October 28, 2022

Re: Soper Hill Station – *Technical Review 2*
PA22030

After reviewing the revised application materials, the Planning Division has the following comments:

A PORTION OF THE SE 1/4, SW 1/4, SEC 1, TWN 29 N, RGE 5 E, W.M. CITY OF MARYSVILLE, SNOHOMISH COUNTY, WASHINGTON

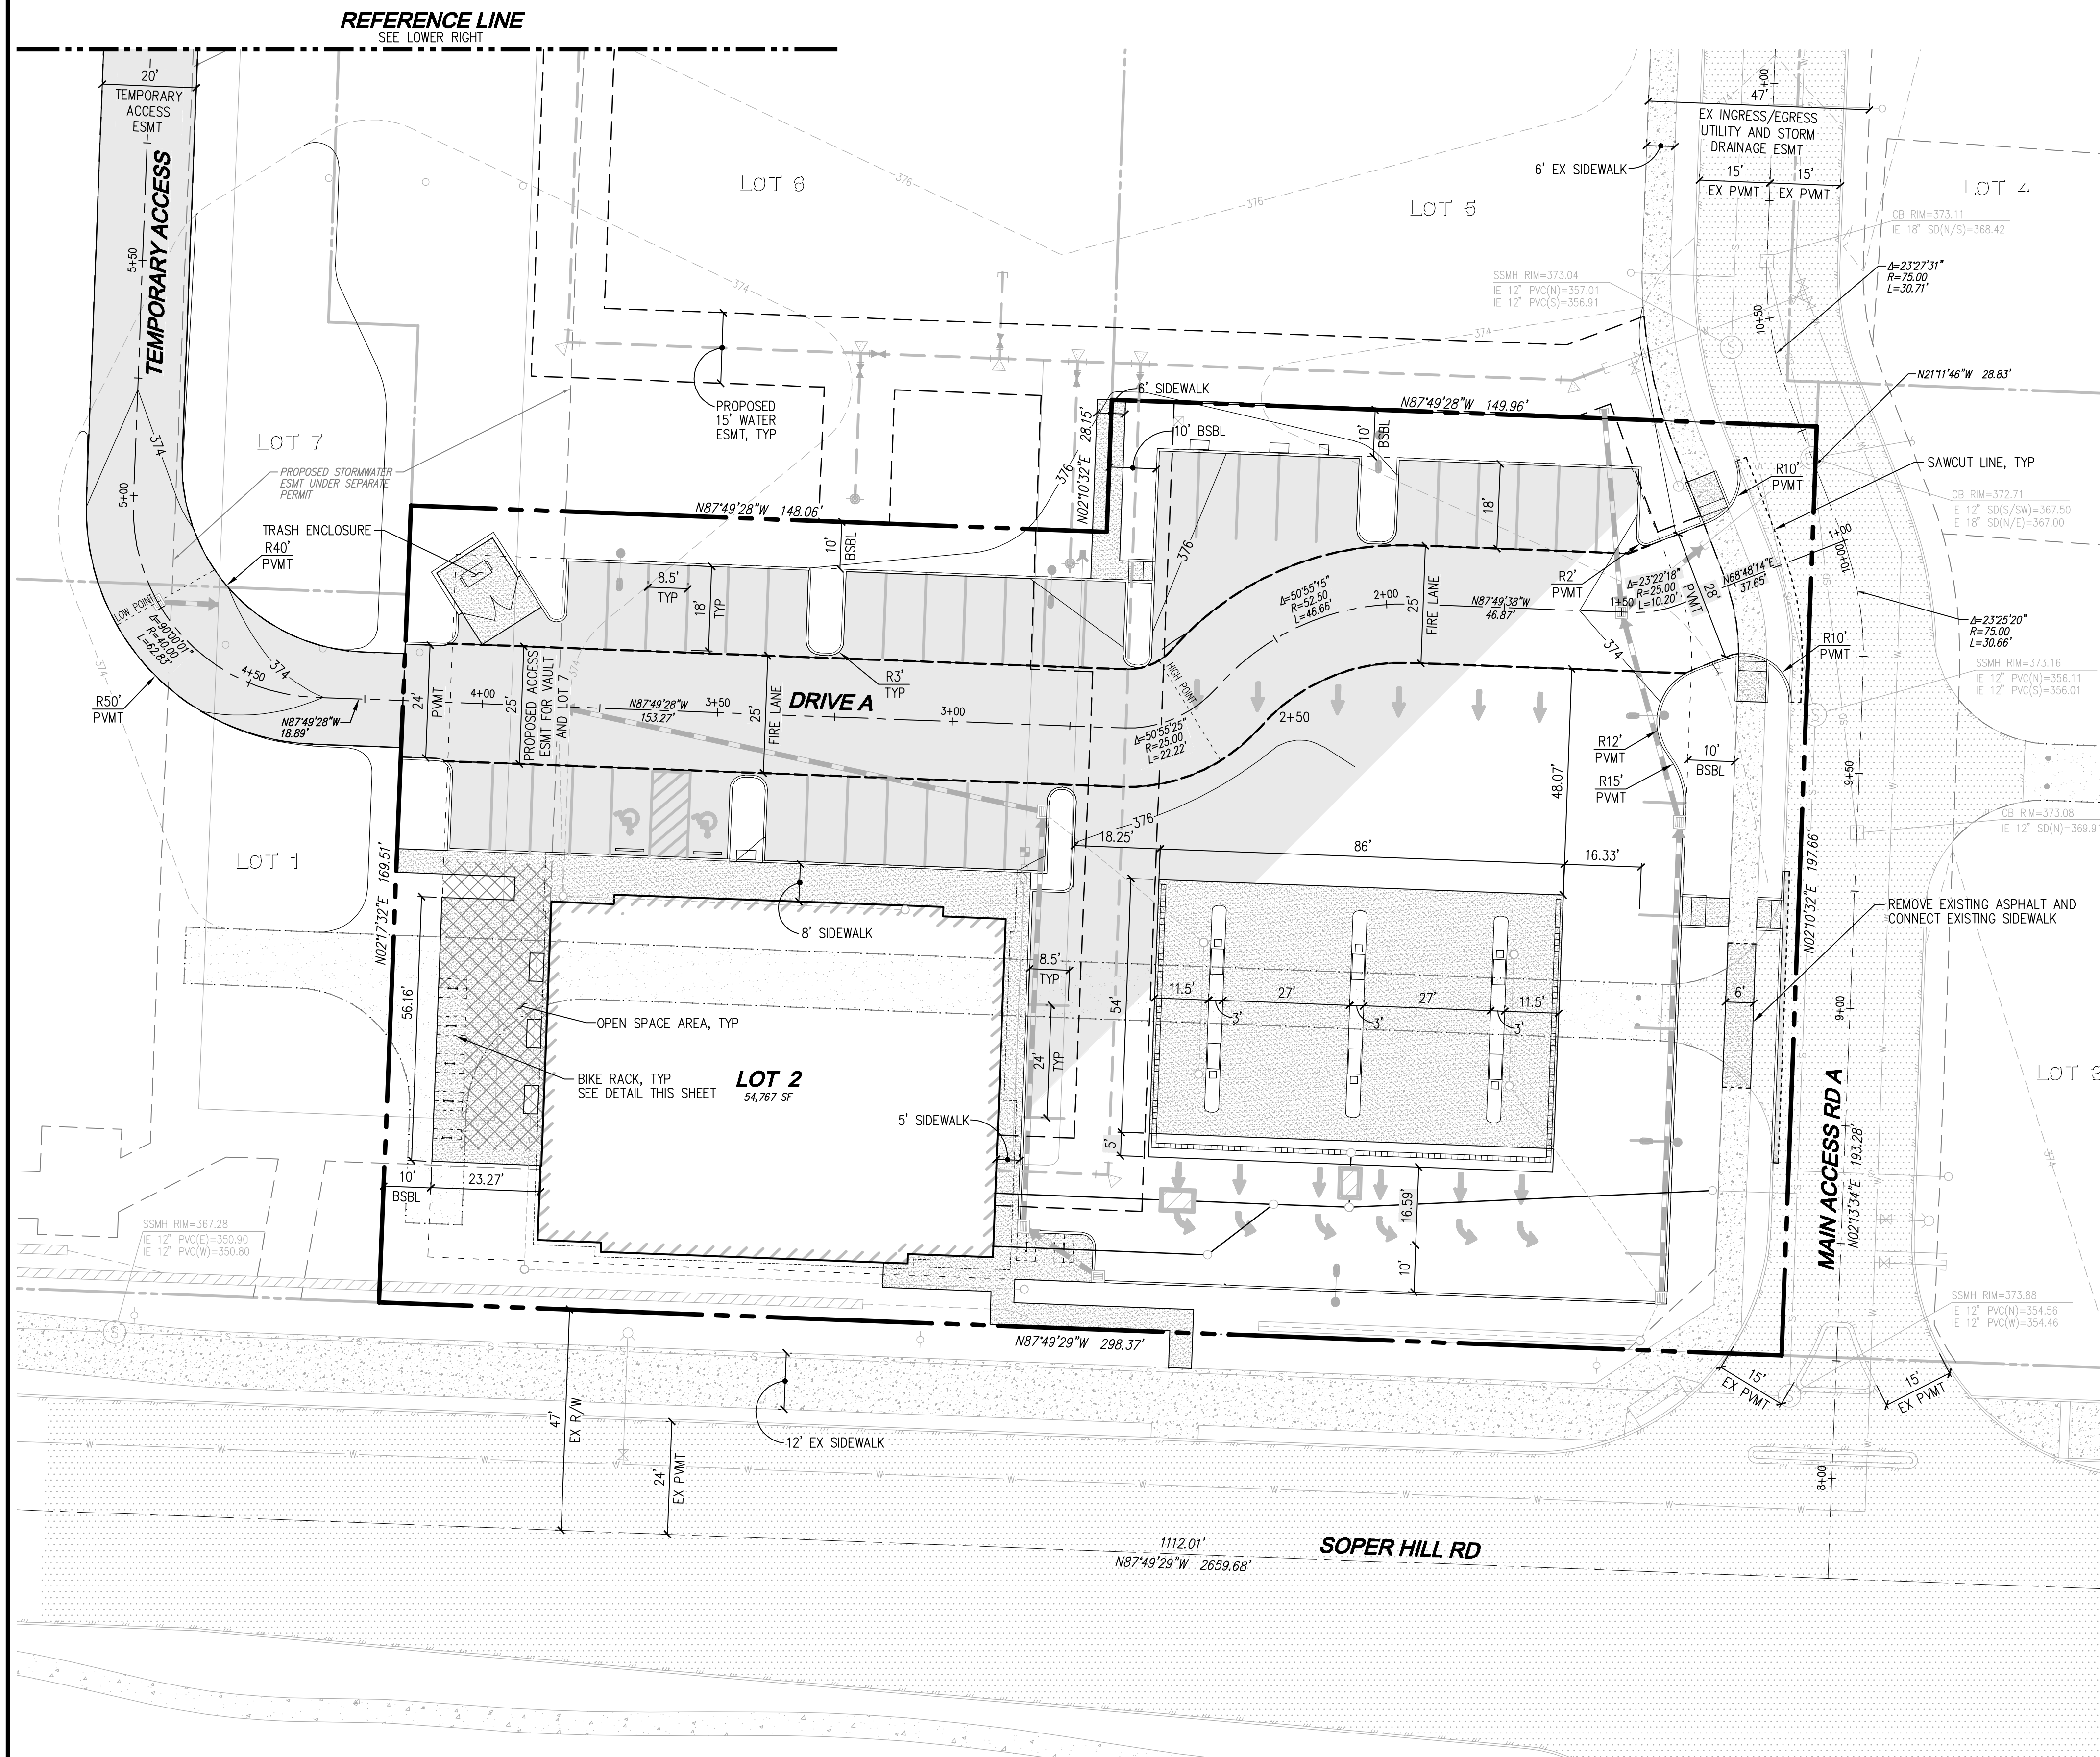
- a. **TR1 Comment:** Provide a pedestrian connection from Lot 2 across the Main Access Drive to Lot 3. Consider potential development of Lots 3 & 4 for location of pedestrian connection.

TR2 Comment: A pre-application has been submitted for Tommy’s Express Carwash for Lot 3. If developed with a carwash undoubtedly passengers of patrons are vacuuming there vehicles will ultimately walk over to the proposed

convenience store. This connection should be coordinated between the two uses and a condition will be added to the preliminary site plan approval.

- b. **TR1 Comment:** B.4.1.a. requires a side and rear setback of 15'. It appears the building is only setback 10' along the south property line.

TR2 Comment: Building is only setback 12' 6" from south property line. Additionally, please remove the "10' BSBL" reference along Soper Hill Road.

- c. **TR1 Comment:** F.1.1 requires a 30' landscaping setback from Soper Hill Road and a 20' setback is required from Road A when a parking areas and drive aisles are located adjacent to these roadways. The *Director* may approve and condition reduced planter widths provided the design meets the intent of the standards and guidelines. For example, reduced widths may be allowed provided the landscaped area is supplemented with architectural features that help to define the street edge and maintain visual continuity along the street. Examples could include a decorative low wall made of stone or masonry that is used in conjunction with landscaping, and/or use of a landscaped trellis or architectural columns. For each method, it is important to maintain visibility at eye level (between 3 and 8 feet above the ground) between the street into the parking lot for safety.

TR2 Comment: I do recall discussing a reduced landscape buffer, however, simply providing a 10' L3 buffer was not what I recall. In order for a reduced landscape buffer to be approved by the director the landscaped area shall be supplemented with architectural features that help to define the street edge and maintain visual continuity along the street. Examples could include a decorative low wall made of stone or masonry that is used in conjunction with landscaping, and/or use of a landscaped trellis or architectural columns. Please provide a proposal for Director consideration.

Applicant’s Response: Pedestrian connection from site to sidewalk along Main Access Drive A has been added. Connection to Lot 2 to be determined when Lot 2 development occurs. No sidewalks are currently proposed on Lot 2, as a site plan has not been approved so no reason to provide a midblock crossing of the access drive at this time.

Applicant's Response: Building has been adjusted to provide appropriate setbacks from property lines and overhead wire.

Applicant's Response: Per our previous conversation a Type L3 10-foot buffer has been provided along both Drive Aisle A and Soper Hill Rd. In addition, landscaping will be provided in the 5-foot planter strips between Soper Hill Rd and Drive Aisle A.
